CITY OF ALBUQUERQUE

**Re: R&M Warehouse
7021 Huseman PI NW
30-Day Temporary Certificate of Occupancy- Transportation Development
Transportation Development Final Inspection
Engineer's/Architect's Stamp dated 6-28-17 (M10D016I)
Certification dated 1-28-18**

TCL LAYOUT
R & M WAREHOUSE

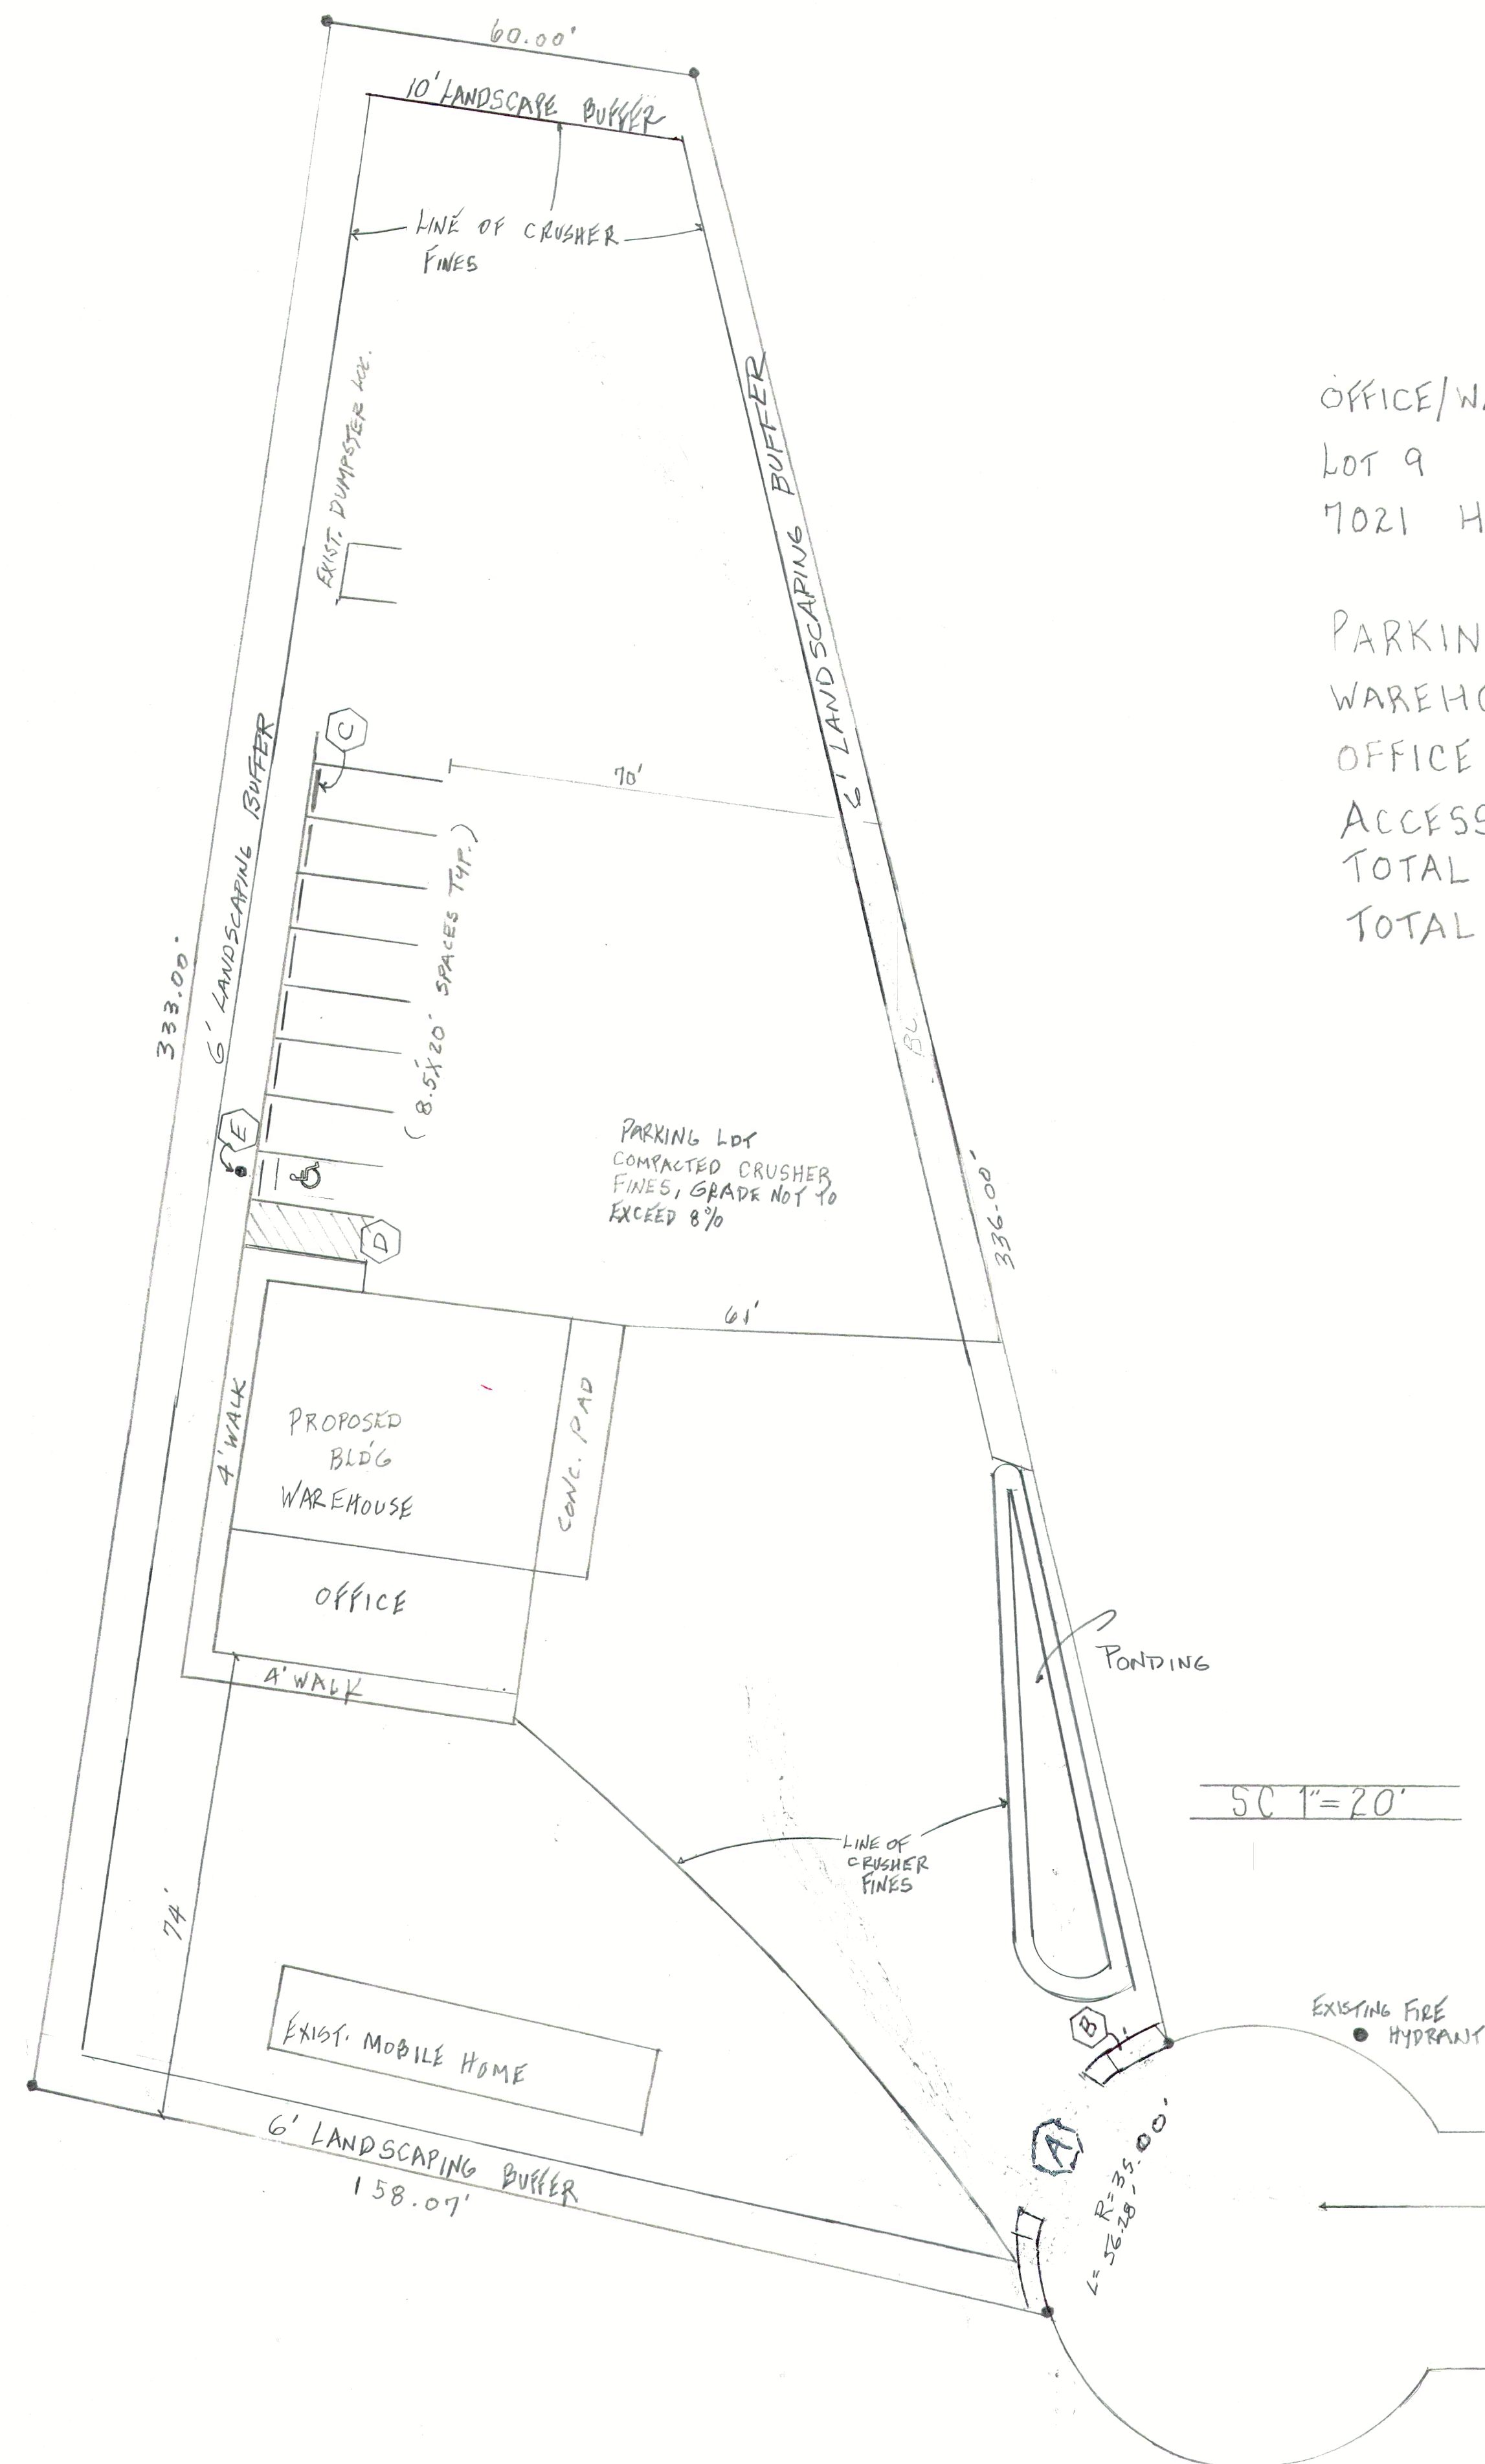
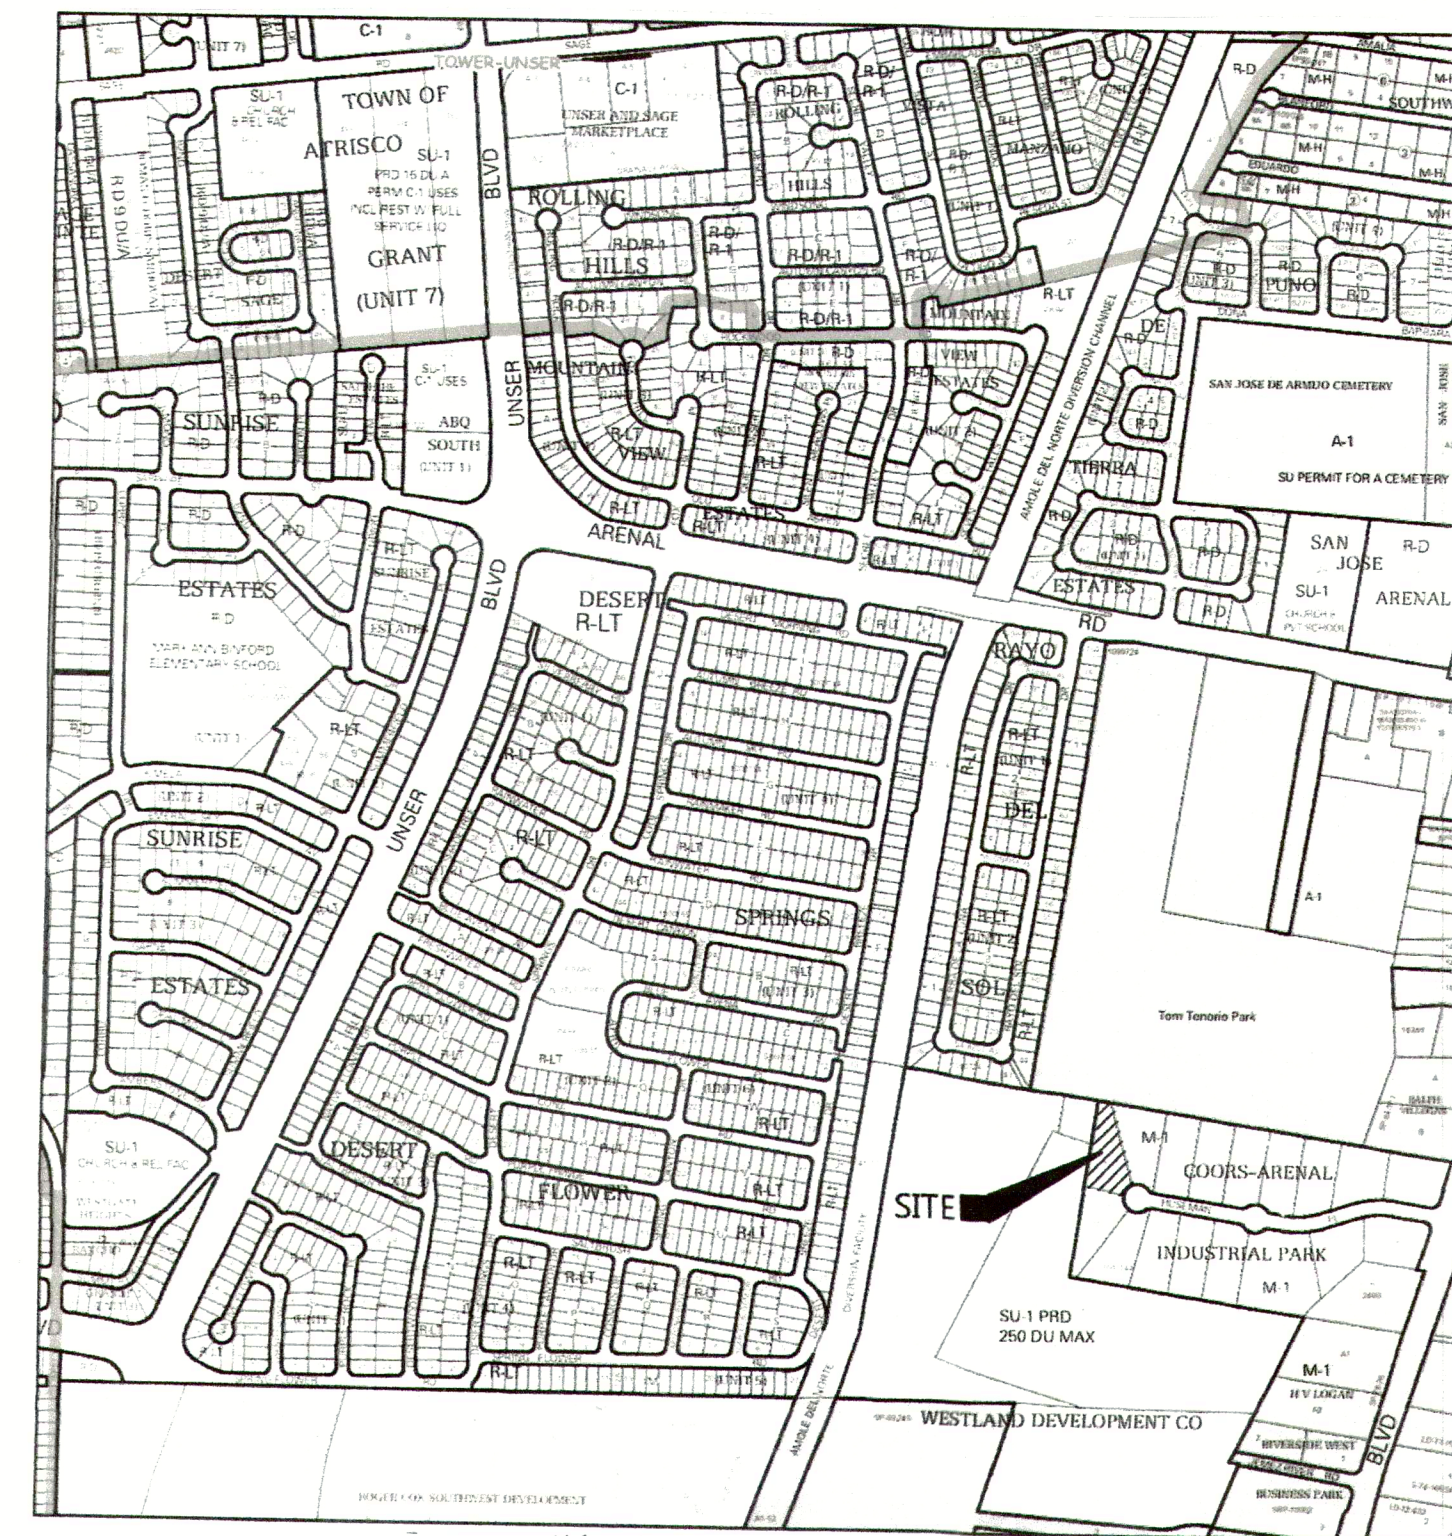
- The ADA access aisles shall have the words "NO PARKING" in capital letters, each of which shall be at least one foot high and at least two inches wide, placed at the rear of the parking space so as to be close to where an adjacent vehicle's rear tire would be placed. (66-1-4.1.B NMSA 1978)
